July 29, 2013

Project Name:	Eyecare Medical Group Building Expansion	Project ID: 2013-136
Address:	53 Sewall Street	CBL: 190 D009 001
Applicant:	Eyeventure	
Planner:	Shukria Wiar

On July 29, 2013, the Planning Authority approved with conditions a Level II site plan for Eyecare Medical Group for a 4,978 square feet building expansion at the existing facility at 53 Sewall Street. The decision is based upon the application, documents and plans as submitted by Eyeventure and prepared by Robert Woodman of FST with a revision date of 07.25.13. The proposal was reviewed for conformance with the standards of Portland’s site plan ordinance.

EROSION CONTROL NOTES & DETAILS
OFF: PARKING LOT EXPANSION
53 SEWALL STREET
PORTLAND, MAINE 04102
FOR: EYE VENTURE ASSOCIATES, LLC
62 SEWALL STREET
PORTLAND, MAINE 04102

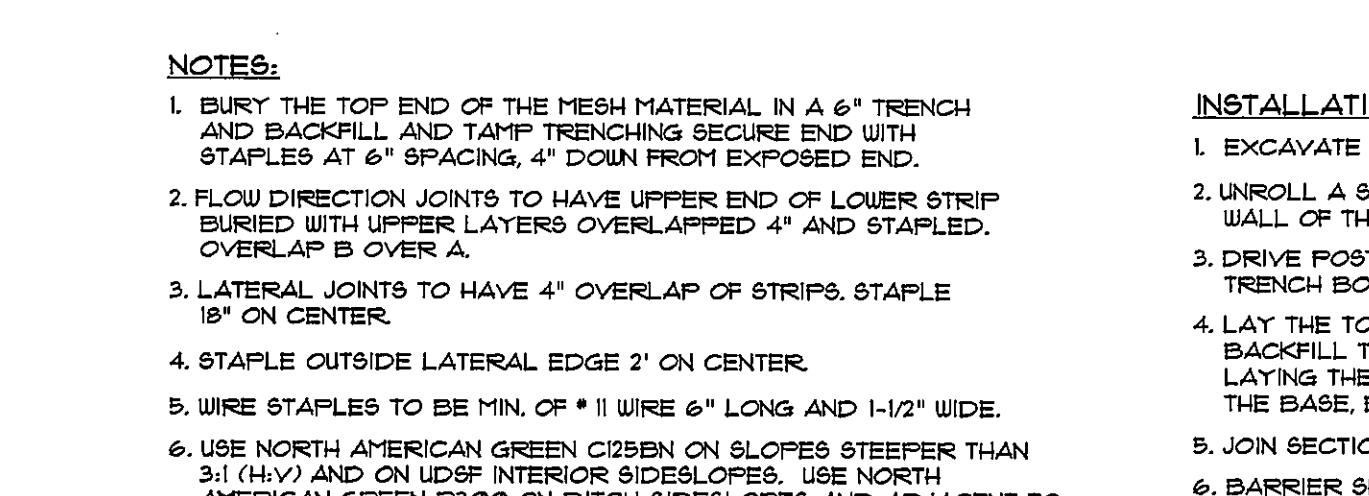
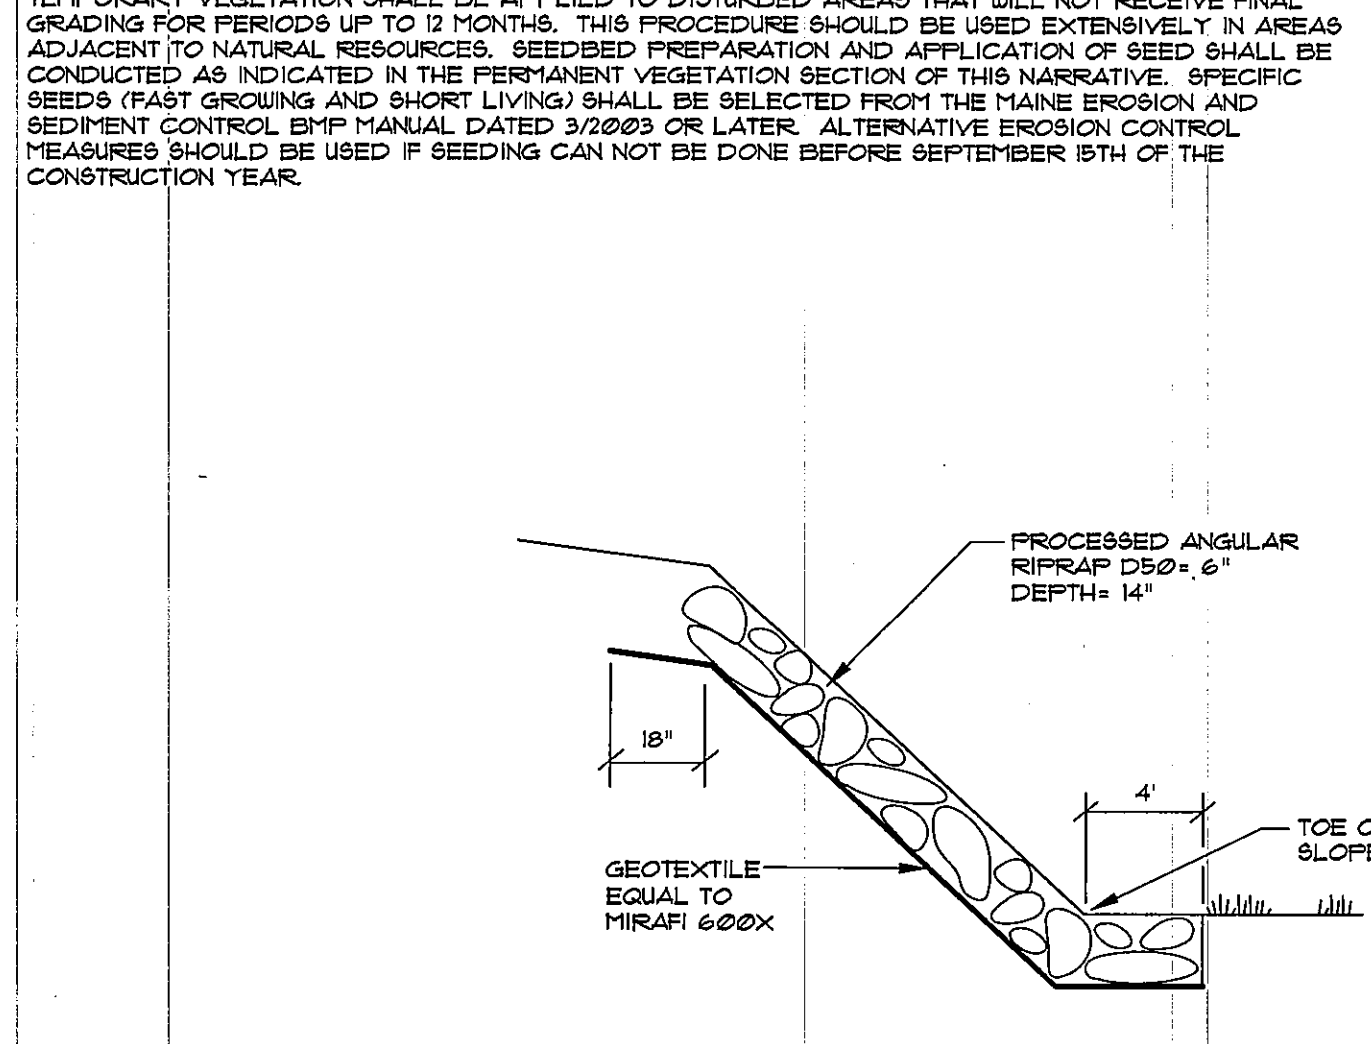
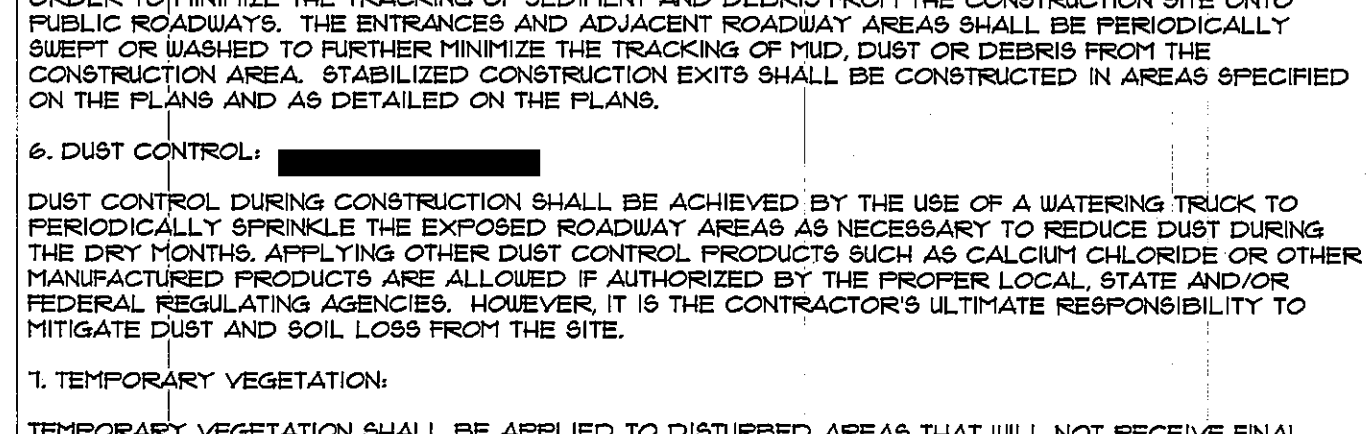
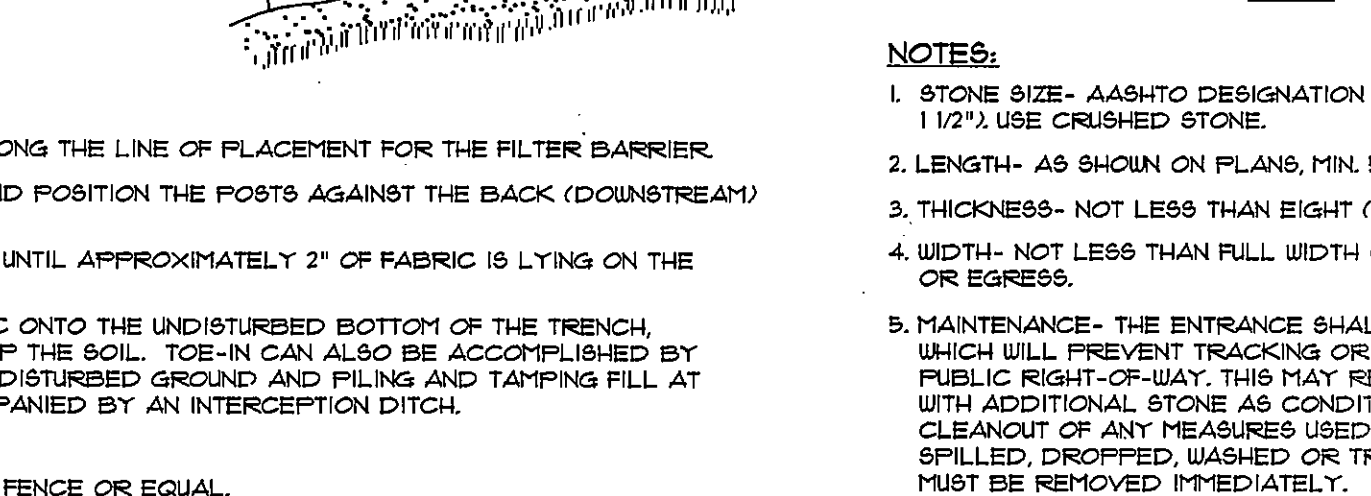
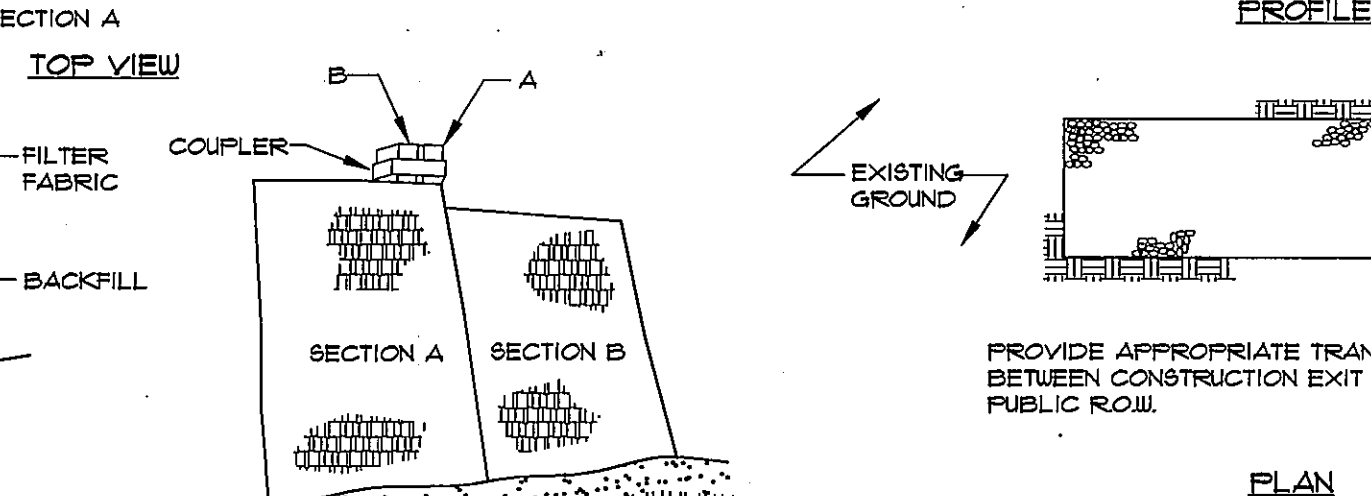
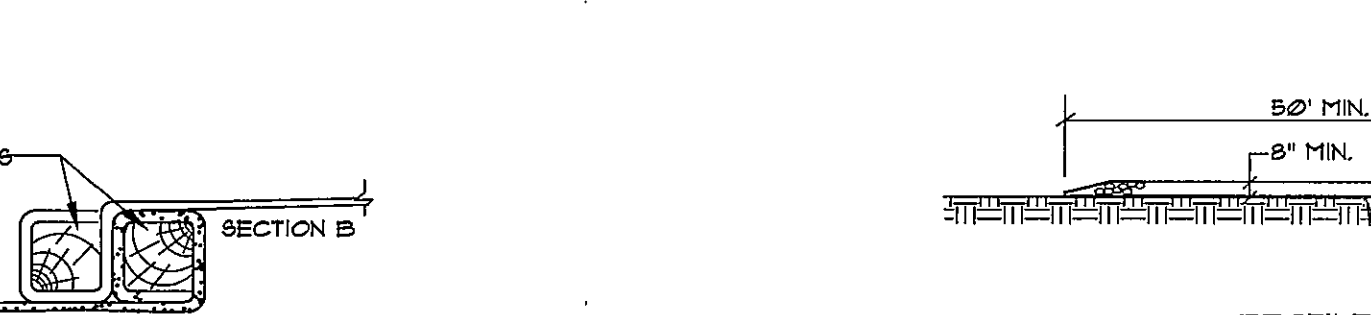
1. A detail for the StormSok shall be included in the final site plans.
2. The developer/contractor/subcontractor must comply with conditions of the construction stormwater management plan and sediment and erosion control plan based on City standards and state guidelines. The owner/operator of the approved stormwater management system and all assigns shall comply with the conditions of Chapter 32 Stormwater including Article III, Post Construction Stormwater Management, which specifies the annual inspections and reporting requirements.
3. A maintenance agreement for the stormwater drainage system, as attached, or in substantially the same form with any changes to be approved by Corporation Counsel, shall be submitted and signed prior to the issuance of a building permit with a copy to the Department of Public Services.
